From: Jill Dickin Schinas
Sent: 31 March 2019 15:02
To: Simon Davis
Subject: Planning Application BR/49/19/OUT

We wish to register our objection to the proposed development of 26 Burnham Avenue, PO21 2JU (BR/49/19/OUT)

Streetscape (Proposed) 1:100
0 2.5 5.0 M

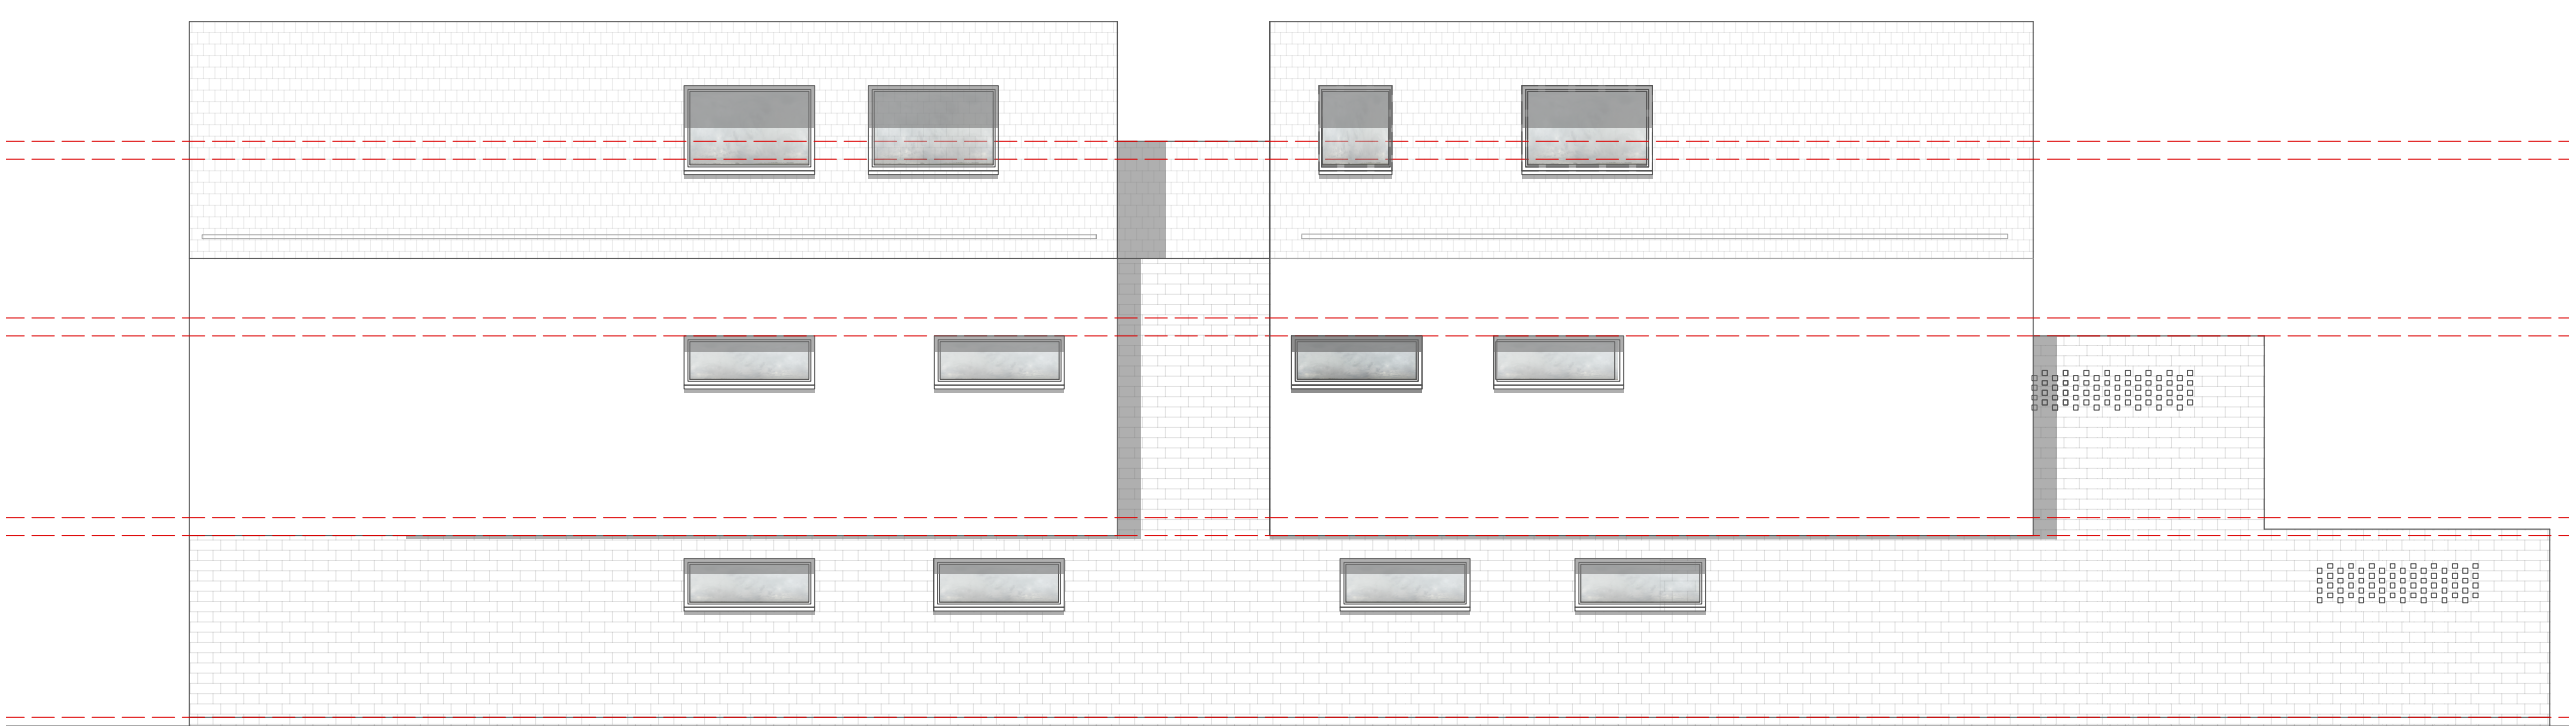
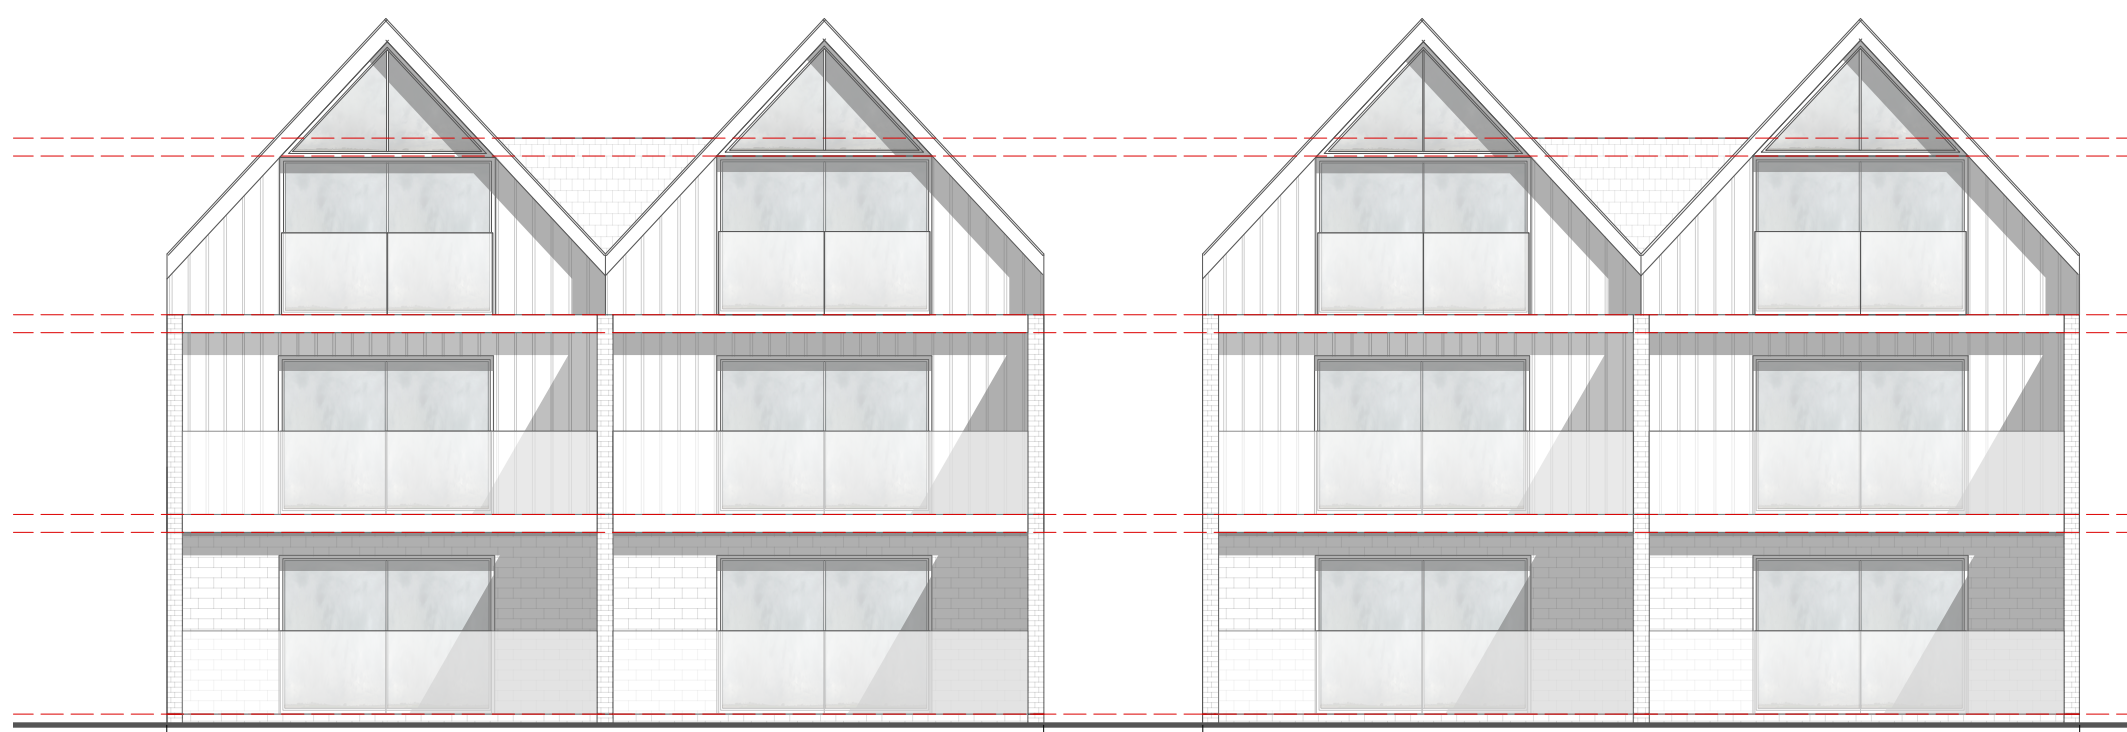
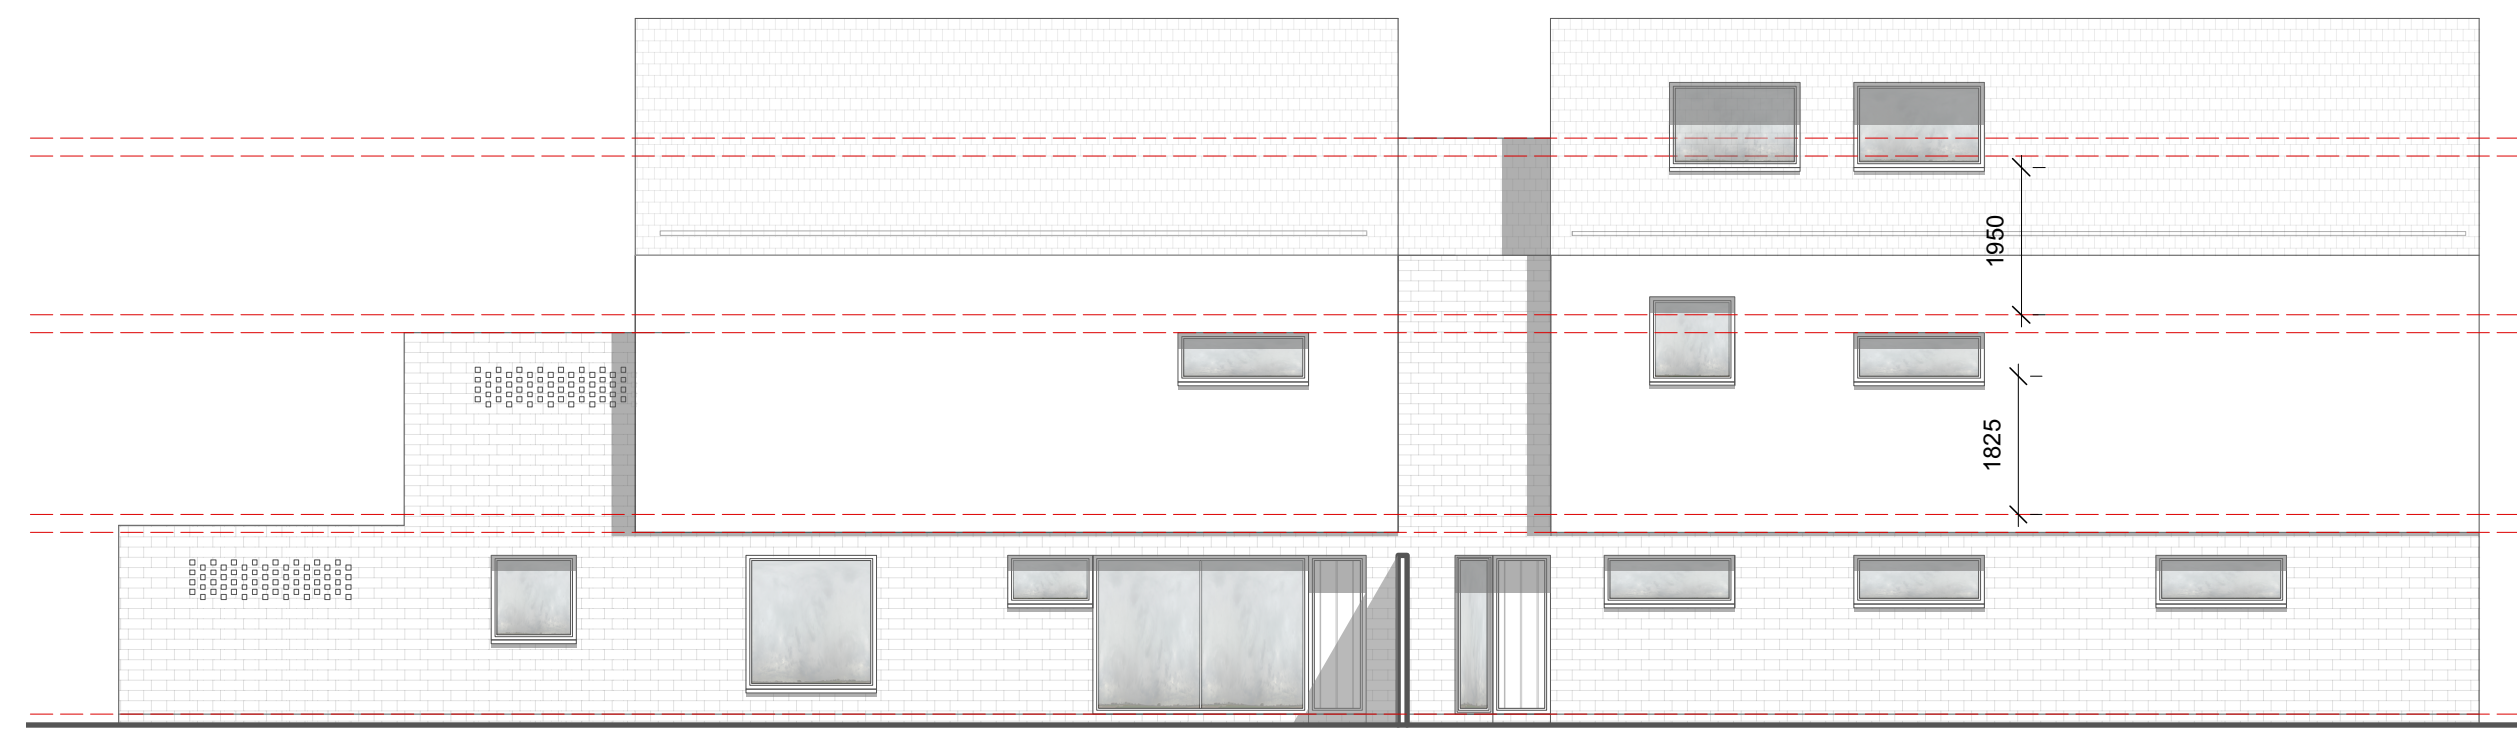
The proposed buildings are large and obtrusive; they will dominate the entire street. At the back, they will overlook hitherto secluded properties in Burnham Gardens, creating an invasion of privacy. Likewise, the

four upper flats at the front of the two buildings will look across into the bedrooms of houses on the opposite side of Burnham Avenue.
